**From:** Graham Evans

**Subject:** RE: Planning Consultation on: AW/120/12/

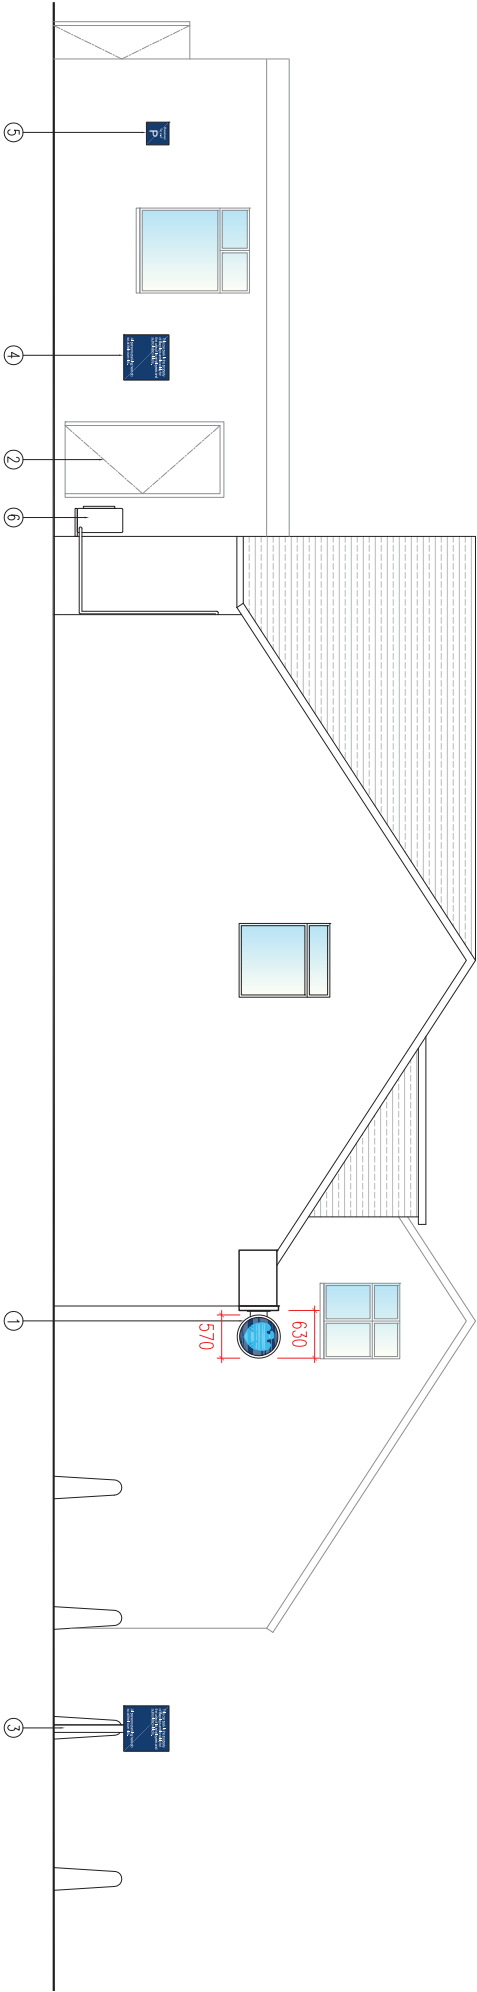
Information suggests that the sound pressure level specified is at 1m from the A/C unit. In my view that due to noise attenuation with distance from the source it is unlikely that noise from the A/C unit will have significant impact at the nearest noise sensitive facade if use is restricted to bank opening hours.
